Consultation Response from: KC Environmental Health (Pollution & Noise Control)
2023/90772 Land at Penistone Road, Fenay Bridge, Huddersfield, HD8 0AW
Discharge conditions 3 (CEMP), 7 (waste collection), 14 (soft landscape), 17 (boundary treatment), 25 (tree/shrub planting) on previous permission 2020/90725 for erection of 68 dwellings with associated access, parking and open space (revised plans)
Responding Date:
6th July 2023

Responding Ref:
WK202319698

Condition 3 Construction Environment Management Plan (CEMP)

Drawing Title	
Construction Management Plan	
Site	
Penistone Road, Fenay Bridge	
Scale @ A1	Date
1:500	06.03.23
Drawn	Checked
BH	.
Drawing No.	Rev.
FB-006	B

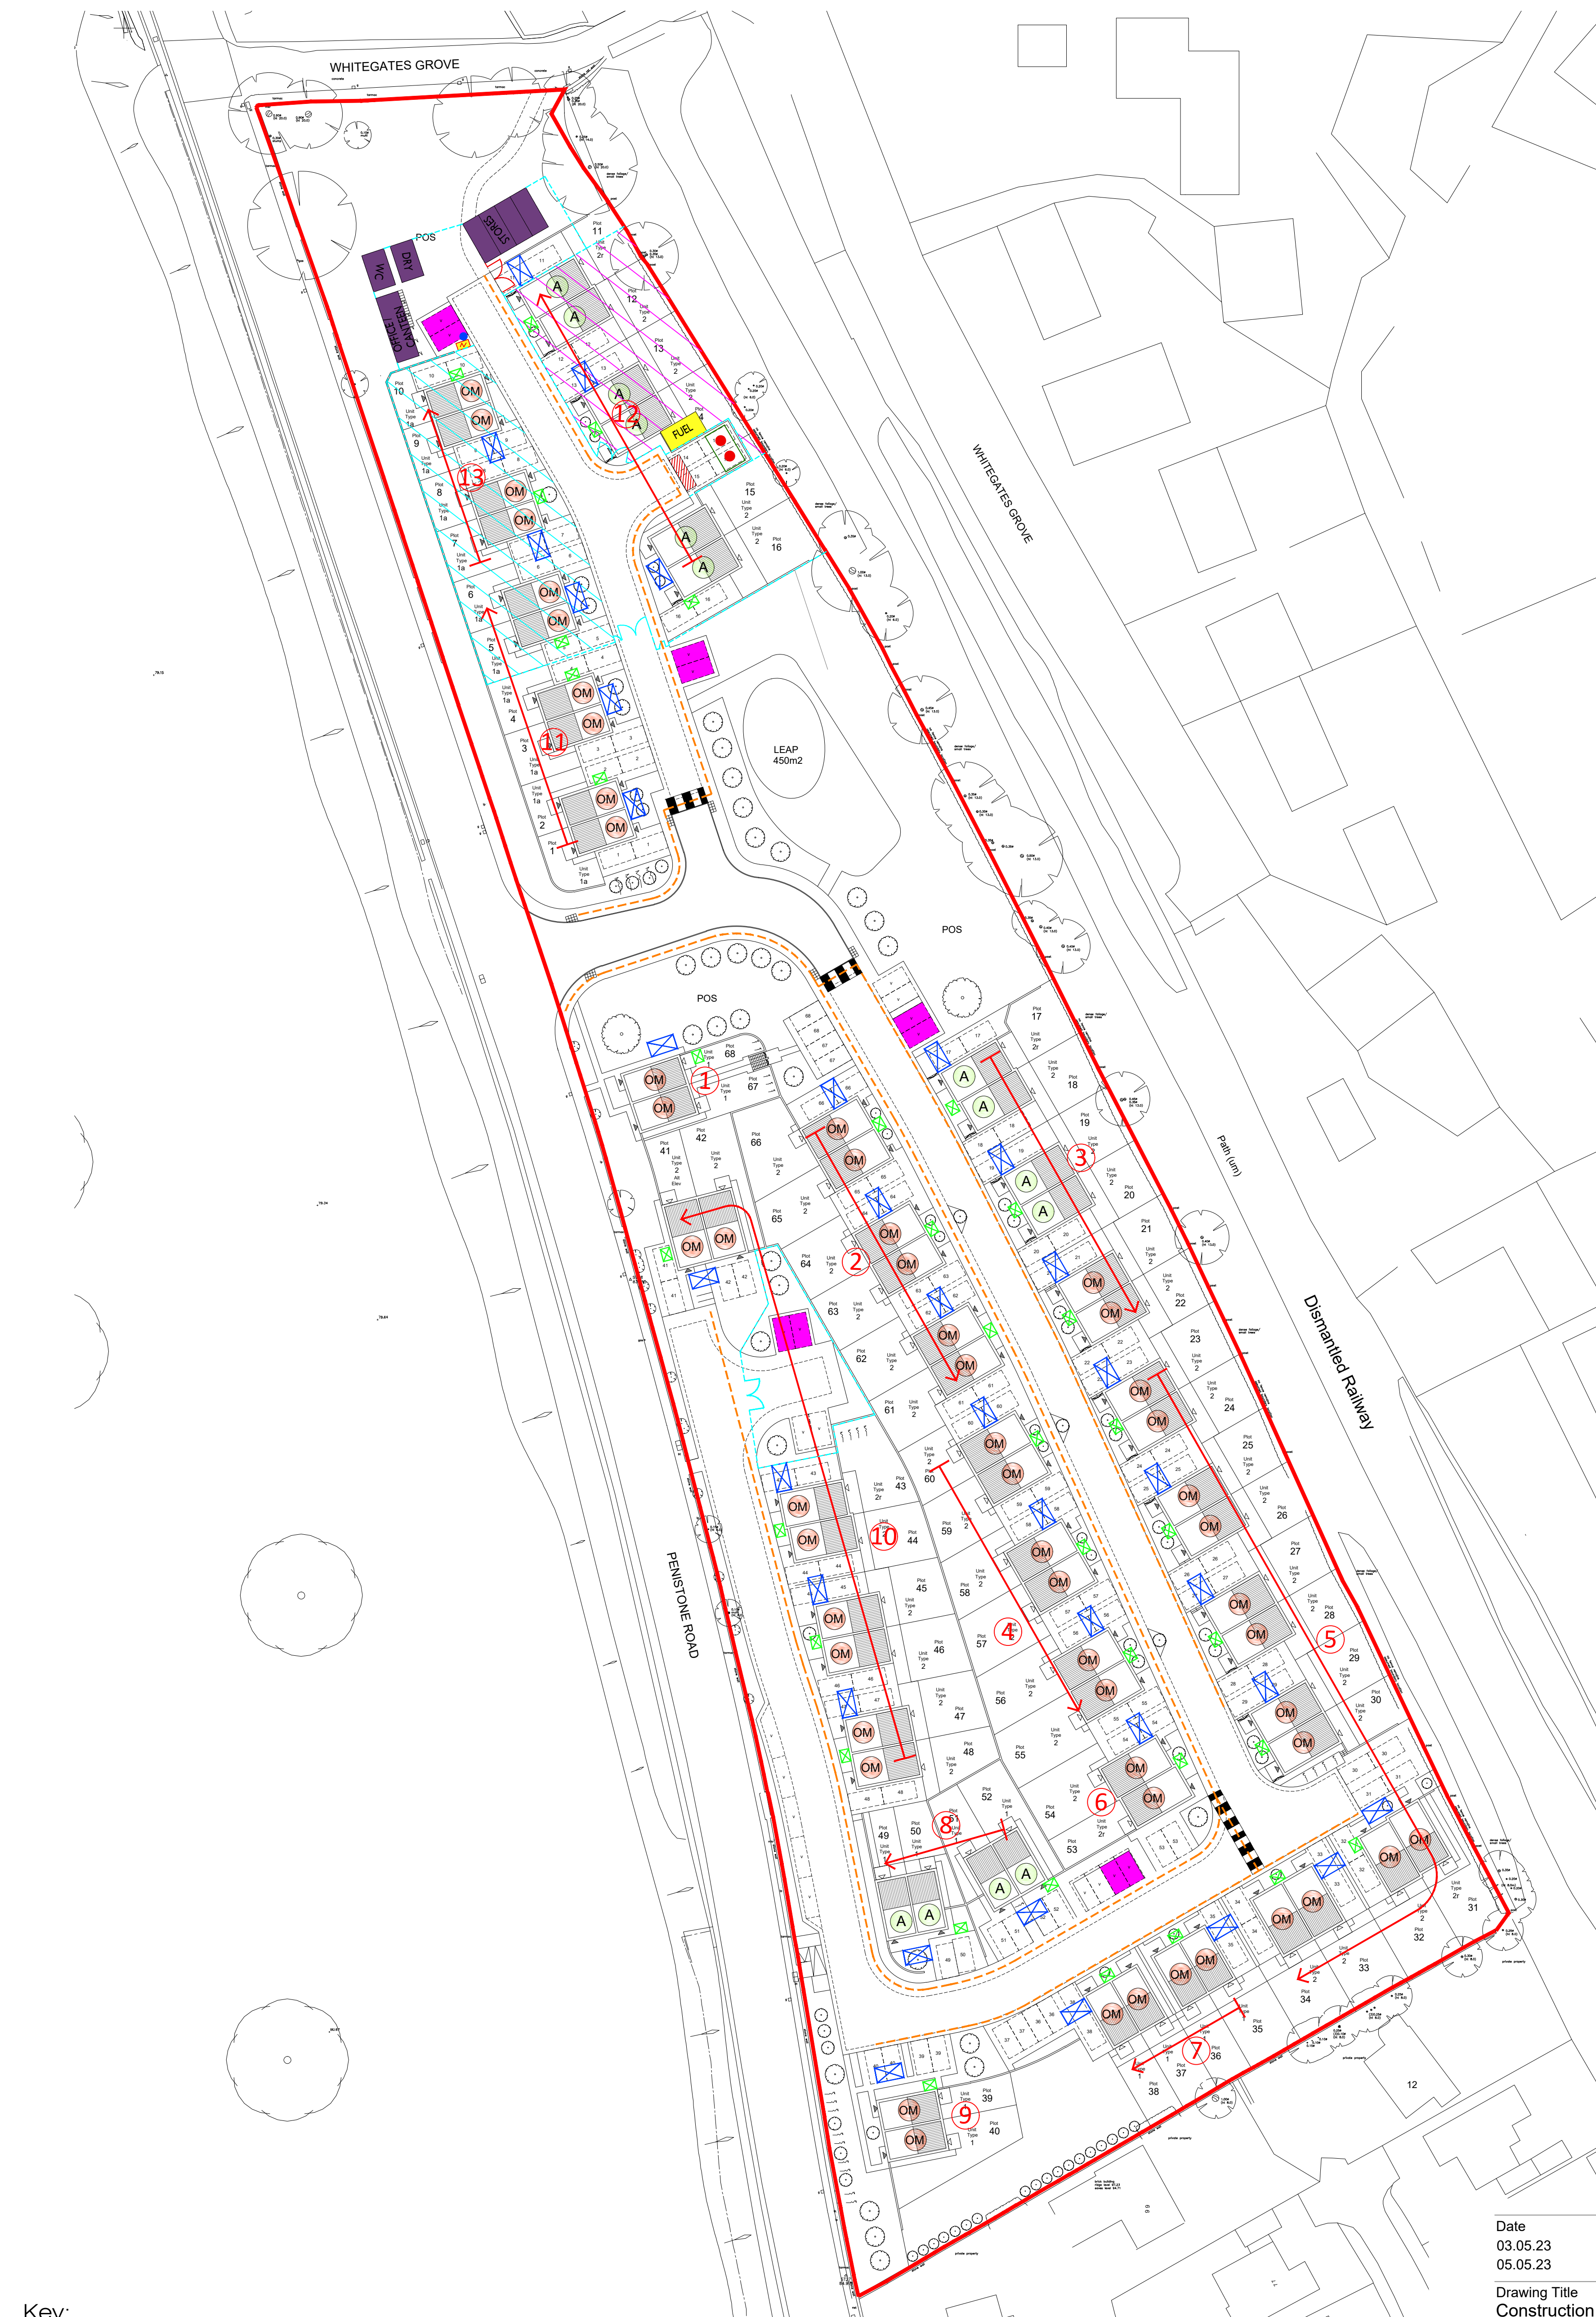
The plan titled Construction Management Plan, drawing no. FB-006, Rev B, dated 5/5/23, provides information on the siting of the compound, silos and contractor parking.

We accept the Construction Management Plan, dated 03/05/2023 by Newett Homes.
